YorkshireWater

**22nd October 2024**

**Land adj 17 Whitehall Road West, Birkenshaw – Erection of 23 dwellings**

Thank you for consulting Yorkshire Water regarding the above proposed development. We have the following comments:

Drawing No: 23/341/500/001
Job No: 23-341
Revision: F
Date: 21.02.24

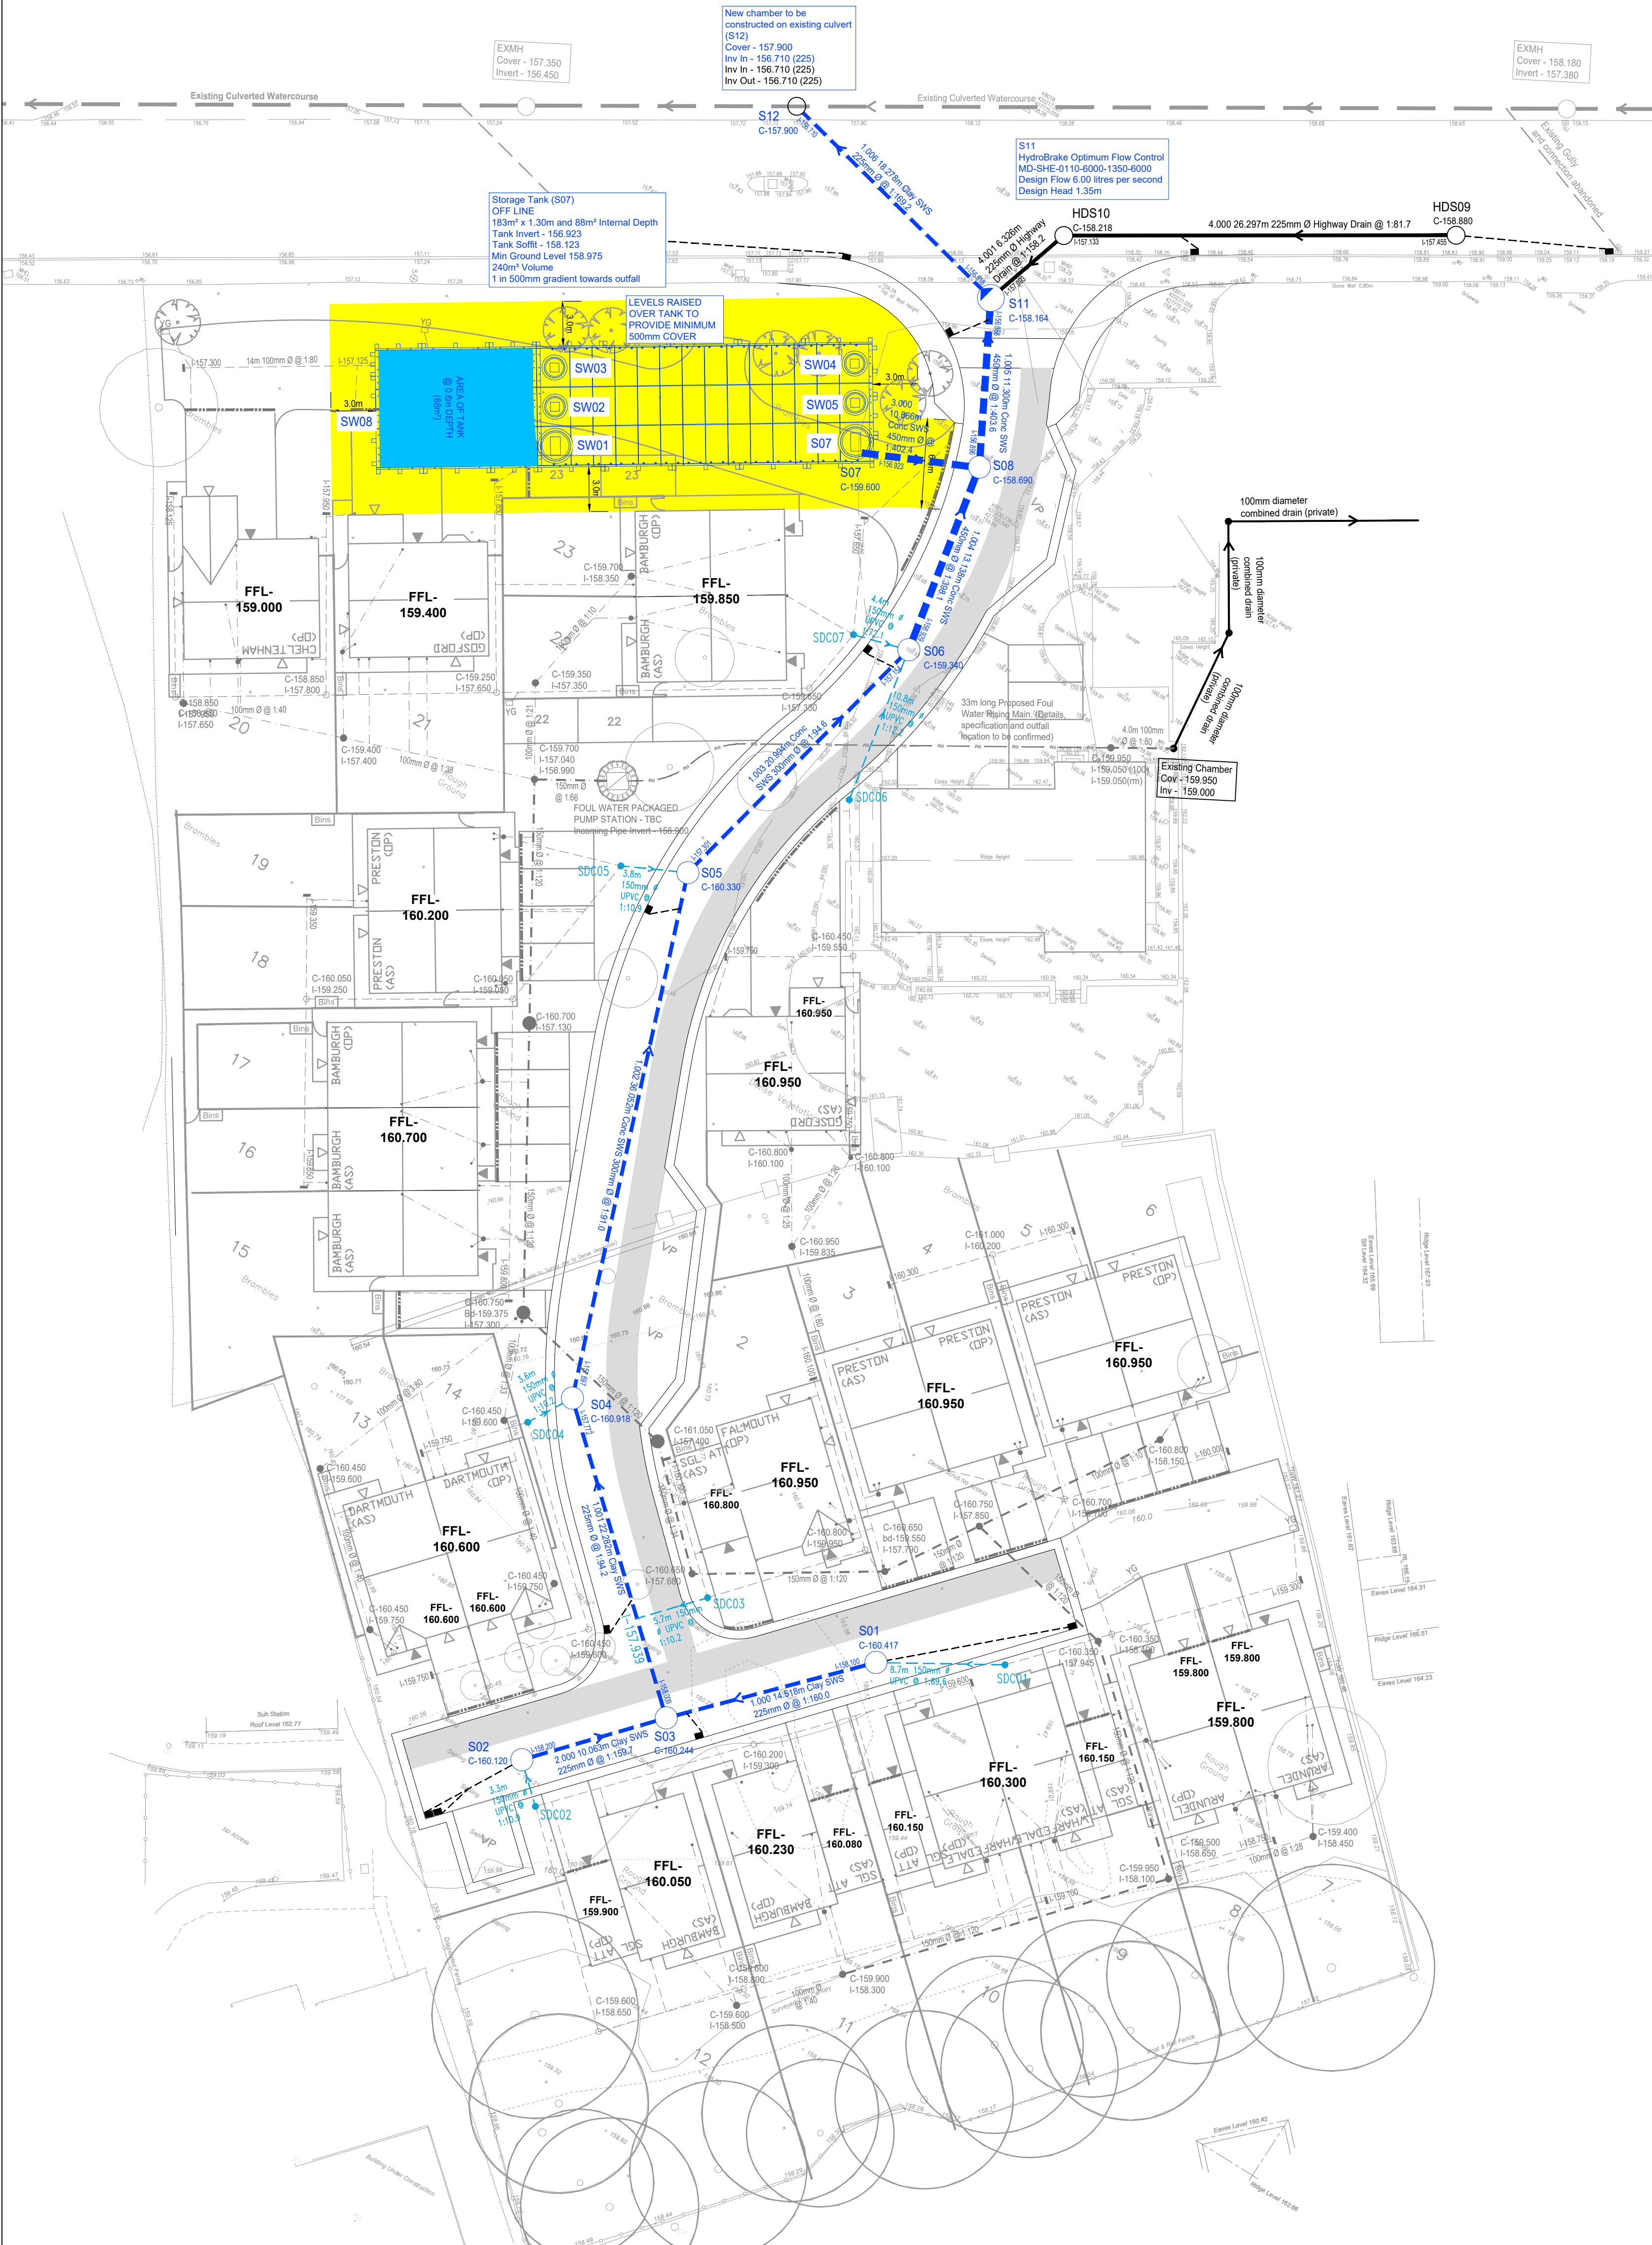
**From the drainage details submitted on drawing 23/341/500/001 (revision F) dated 26/07/2024 that has been prepared by Bryan G Hall, it is noted the proposals are to discharge foul water to a 100mm diameter drain adjacent to the site. This drain and the public sewer immediately downstream of the drain does not have adequate capacity to accommodate the foul flows from the site. We therefore OBJECT to the point of discharge as currently shown. I strongly advise that, prior to determination of this application, the point of discharge is amended to allow for adequate protection of the sewers. For further information, the developer should contact our Developer Services Team: telephone 0345 120 84 82 (option 1) or email [technical.sewerage@yorkshirewater.co.uk](mailto:technical.sewerage@yorkshirewater.co.uk).**

1) The foul water details submitted on drawing 23/341/500/001 (revision F) dated 26/07/2024 that has been prepared by Bryan G Hall are not acceptable and require amendments

acceptable. The following points should be addressed:

- a) The submitted drawing shows foul water is proposed to discharge to a private 100mm diameter combined drain that serves 1 – 15 Whitehall Road West, this is not a suitable point of discharge, this drain does not have the capacity to accept the foul flows generated from this development, the proposals will cause loss of amenity for the residents of the existing dwellings.
- b) Foul water domestic waste should discharge directly to the 225 mm diameter public foul water sewer recorded in Whitehall Road West, at a point to the east of the site.
